Office of  
Environment  
& Heritage

DOC17/339451  
SSD 8114

**Notice of Exhibition - Lindfield Learning Village, 100 Eton Road, Lindfield (SSD 8114)**

## **ATTACHMENT – OEH comments on the exhibited EIS for Lindfield Learning Village at 100 Eton Road, Lindfield (SSD 8114)**

Plan COLA showing rainwater tanks below concrete seating

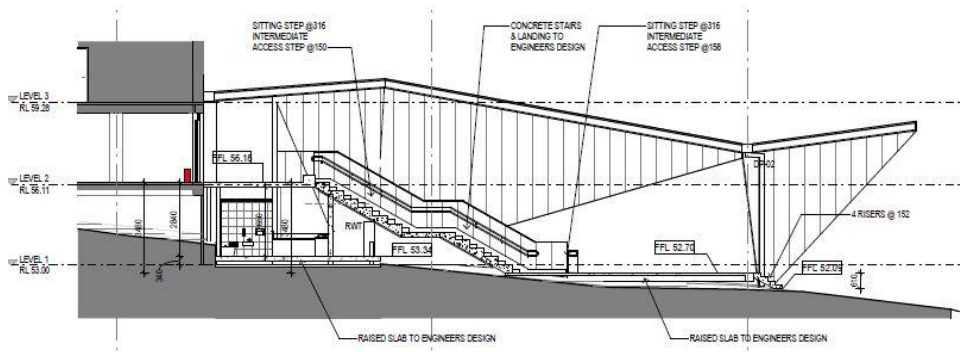
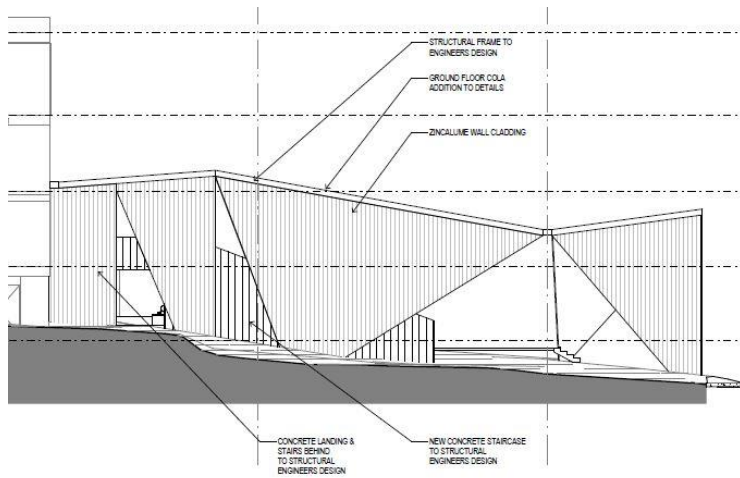
- a. Any upgrades to the existing sewer and stormwater system (both of which run through the NP) and associated impacts.
- b. Stormwater management and treatment for the site. Proposed outdoor play areas which will have synthetic surfaces will require stormwater treatment prior to discharge into the NP.
- c. How the NP will be delineated from the site during construction and operational phases of the project, e.g. by permanent fencing.
- d. A lighting study to ensure that any light spill does not significantly impact on the natural values of the NP.
- e. The contamination assessment should outline any potential impacts on the NP during remediation.
- f. All asset protection measures are contained within the site, and there is no expectation for OEH to change its fire management regime for the land it manages, e.g. by altering or removing vegetation within the NP.

OEH notes that item (b) above has not been addressed in the EIS. It is therefore requested that this matter be addressed. As stated above, all asset protection measures must be contained within the site.
